City of Albuquerque Stormwater Construction Site Inspection Report

| General Information | | | | | |
|---|---|--|-------------------------|---------------|-----------|
| ESC File No. | L21E059B | Project Name: | Take 5 Car Wash Central | | |
| NPDES Id. No. | NMRI005E8 | Location: | 10415 Central Ave NE | | |

UTILITY COORDINATION
CONTRACTOR SHALL FIELD VERIFY ALL UTILITY
LOCATIONS PRIOR TO CONSTRUCTION

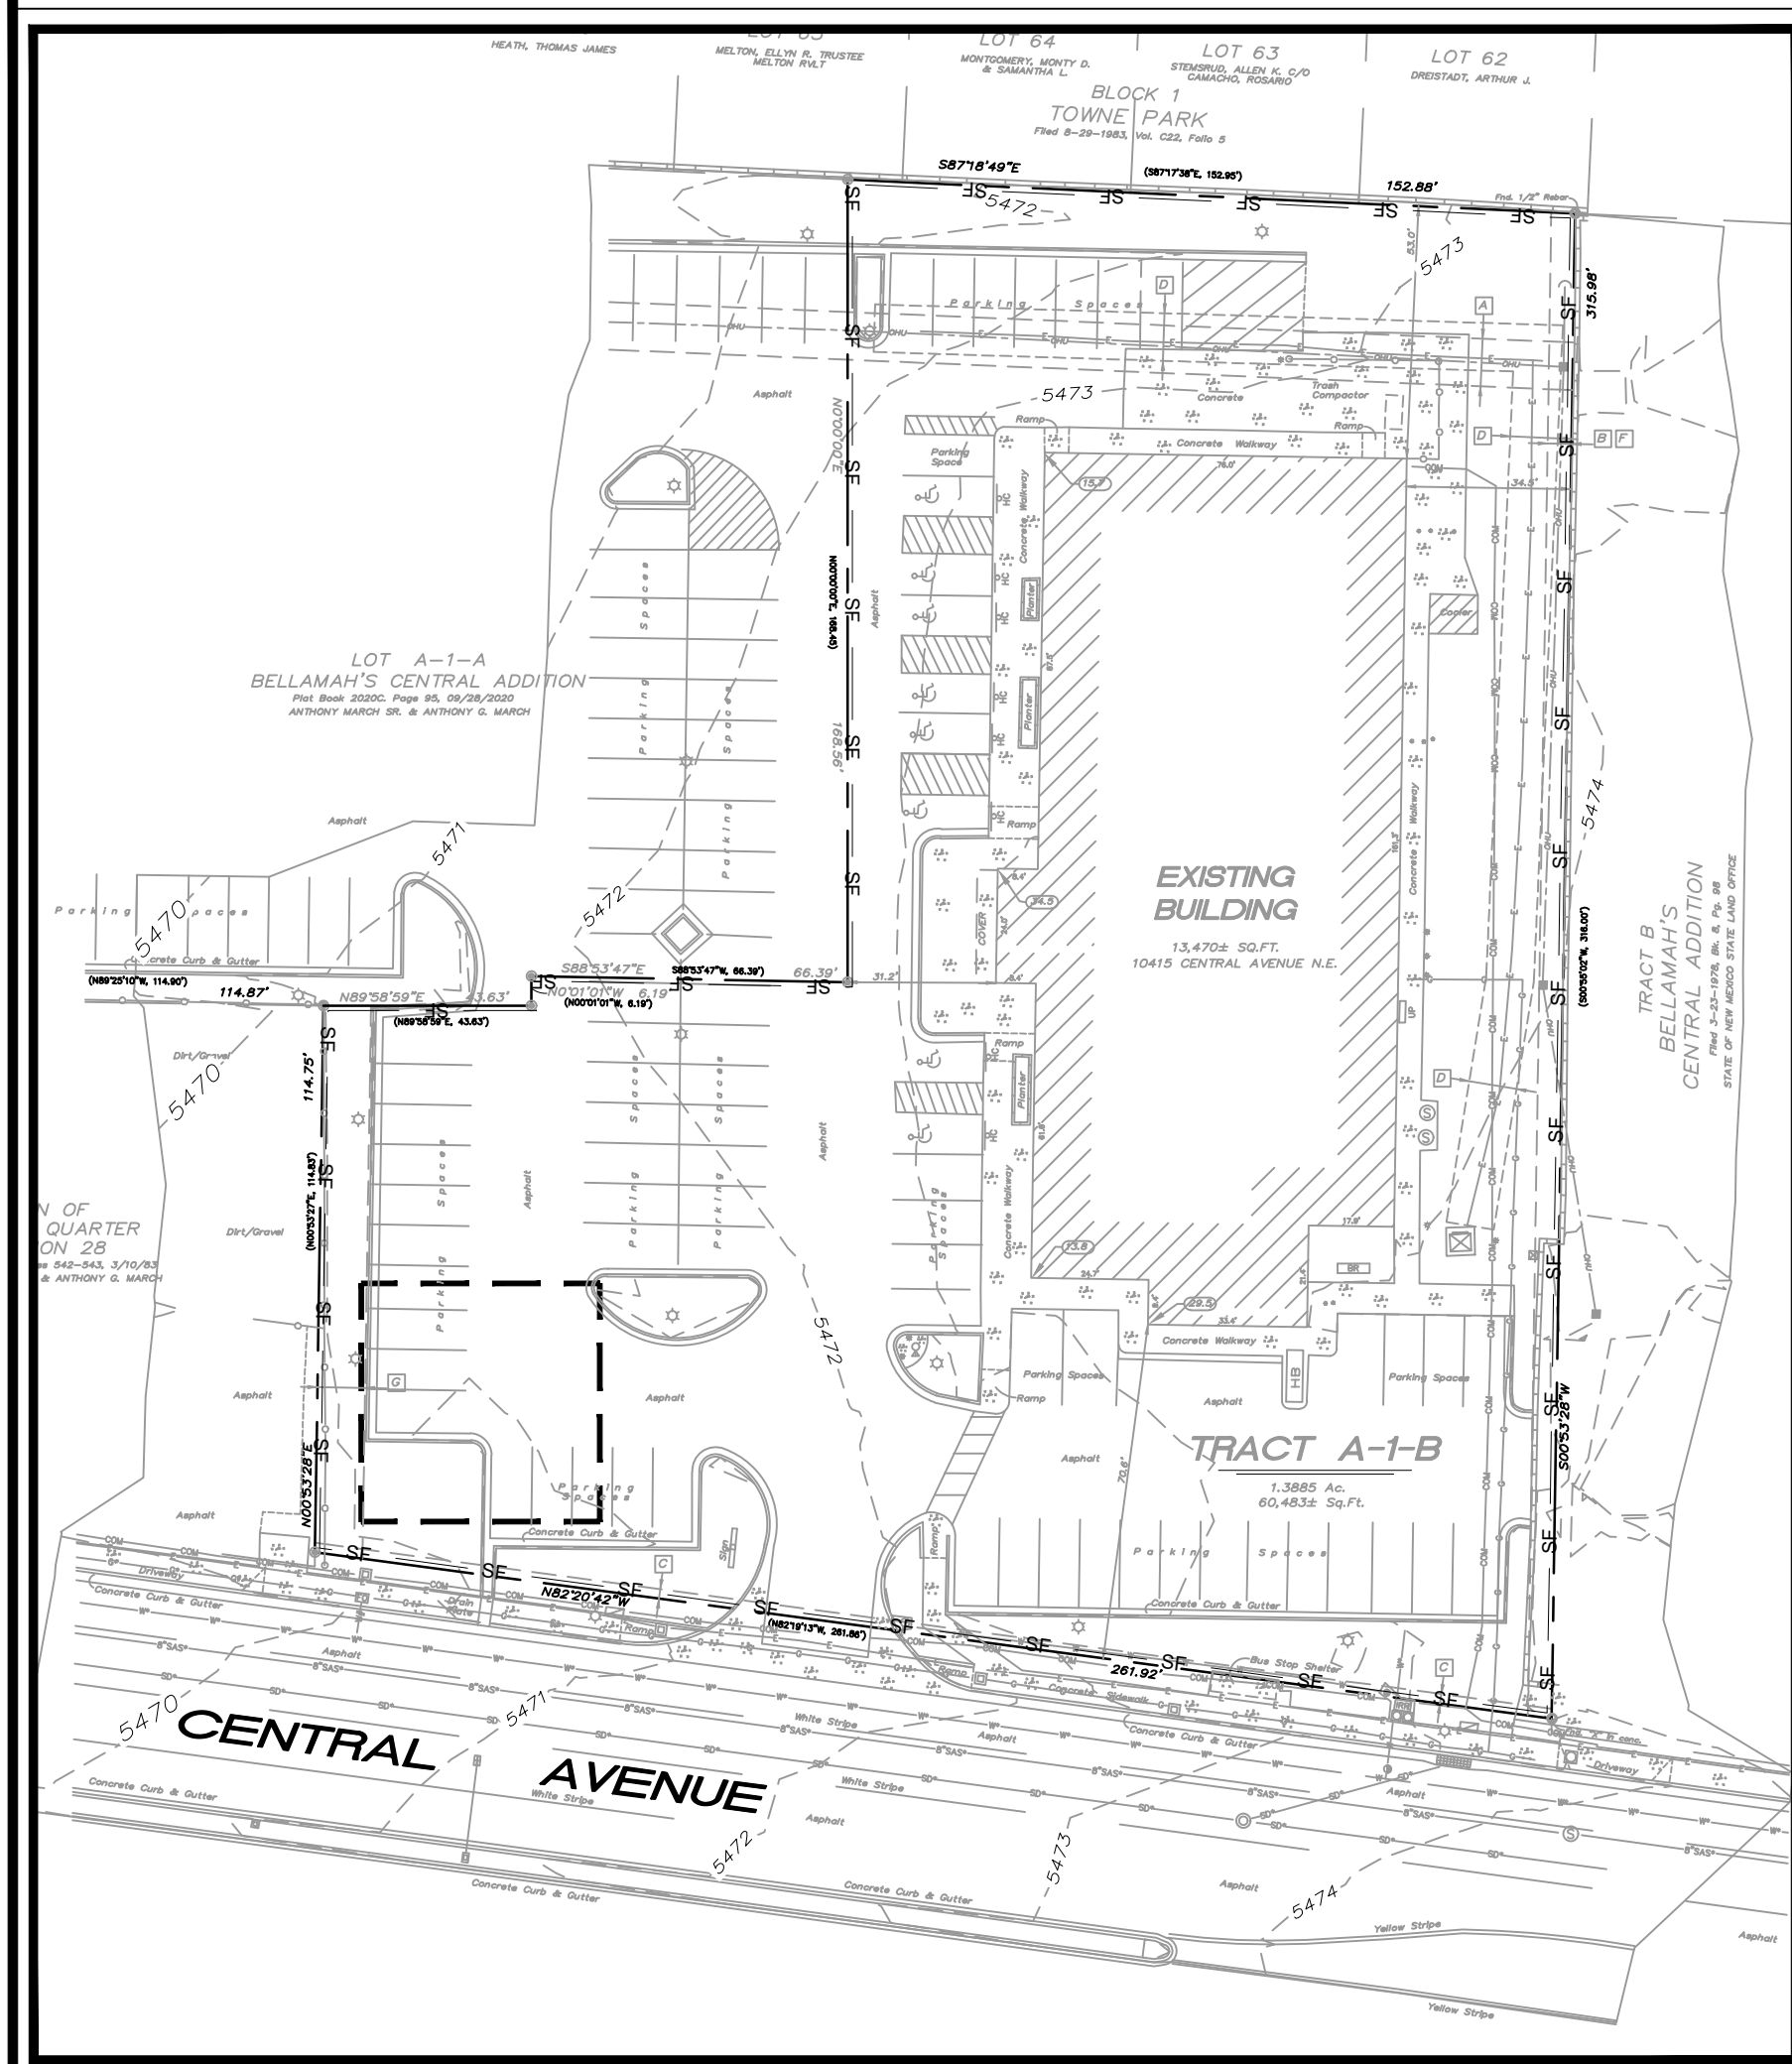
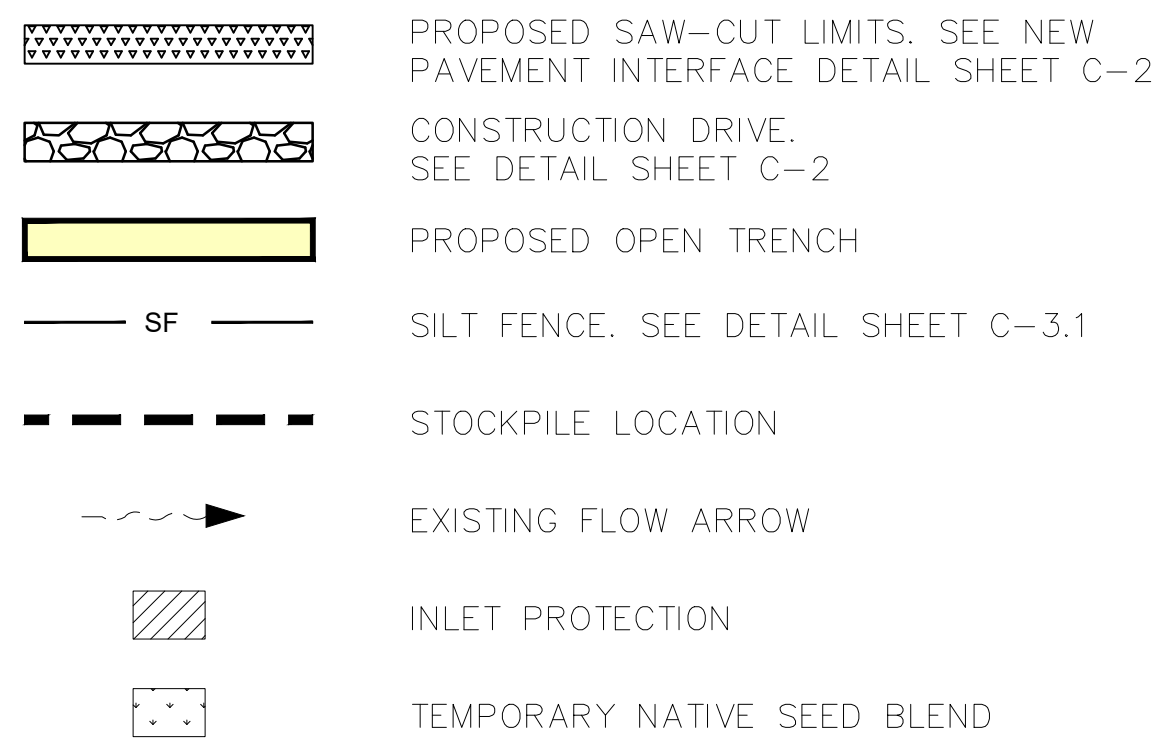
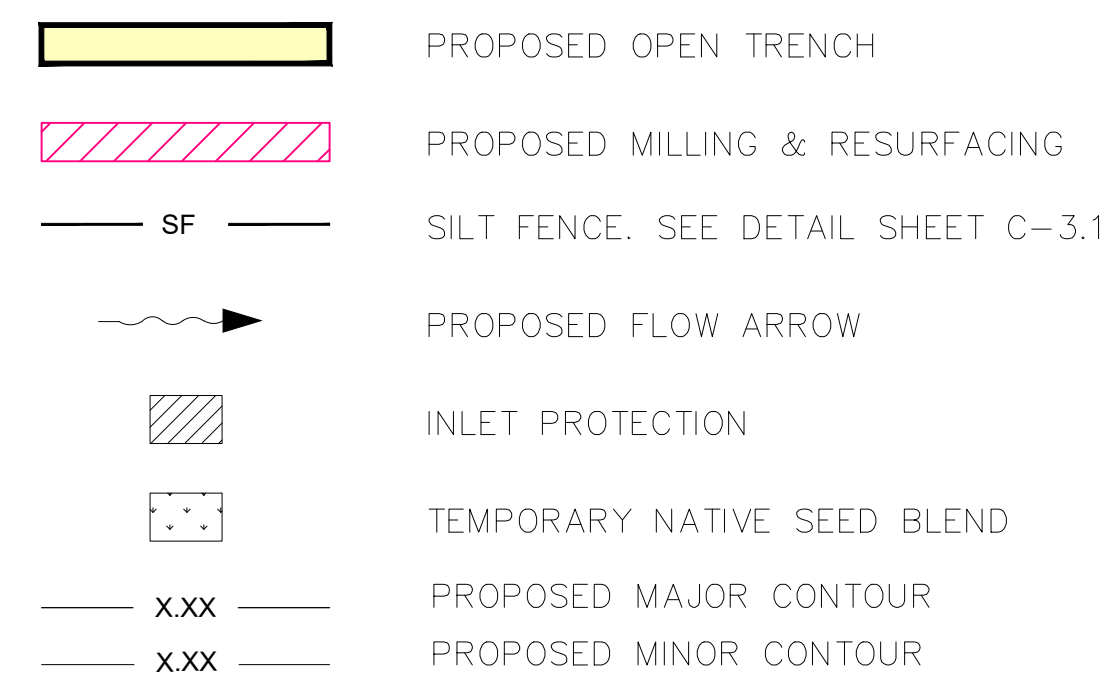
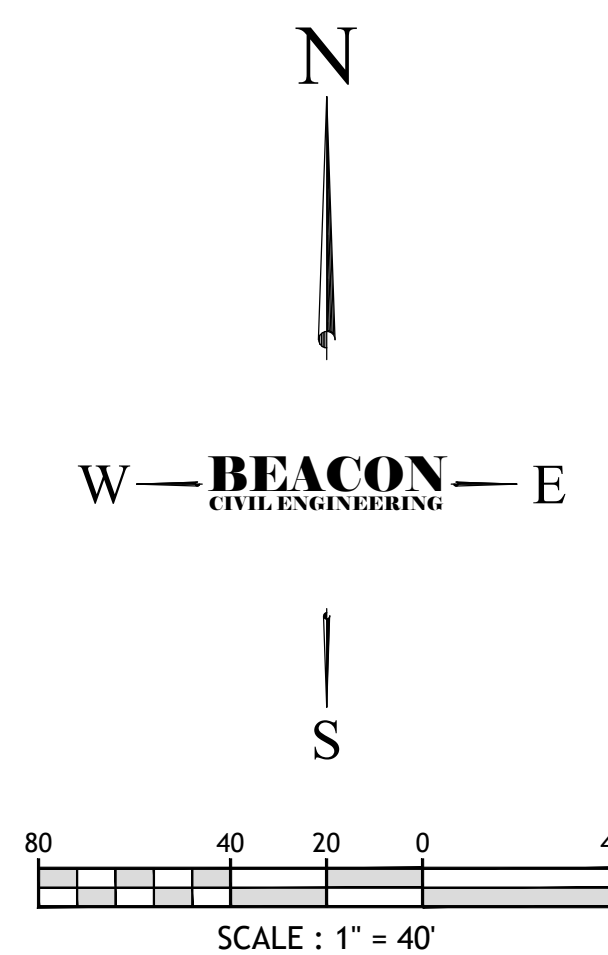
| 3 | BMP - The perimeter stormwater controls (silt fence and wattles) need repair and maintenance in violation of CGP Part 2.1.4. Required mitigation: Ensure that all stormwater controls (BMPs) are maintained and remain in effective operating condition during permit coverage per CGP 2.1.4. If at any time you find that a stormwater control needs routine Maintenance, you must immediately initiate the needed maintenance work and complete such work by the close of the next business day per CGP 2.1.4.b. When the problem requires a new or replacement control or significant repair, install the new or modified control and make it operational or complete the repair by no later than seven (7) calendar days from the time of discovery per CGP 5.2.1. | | | |
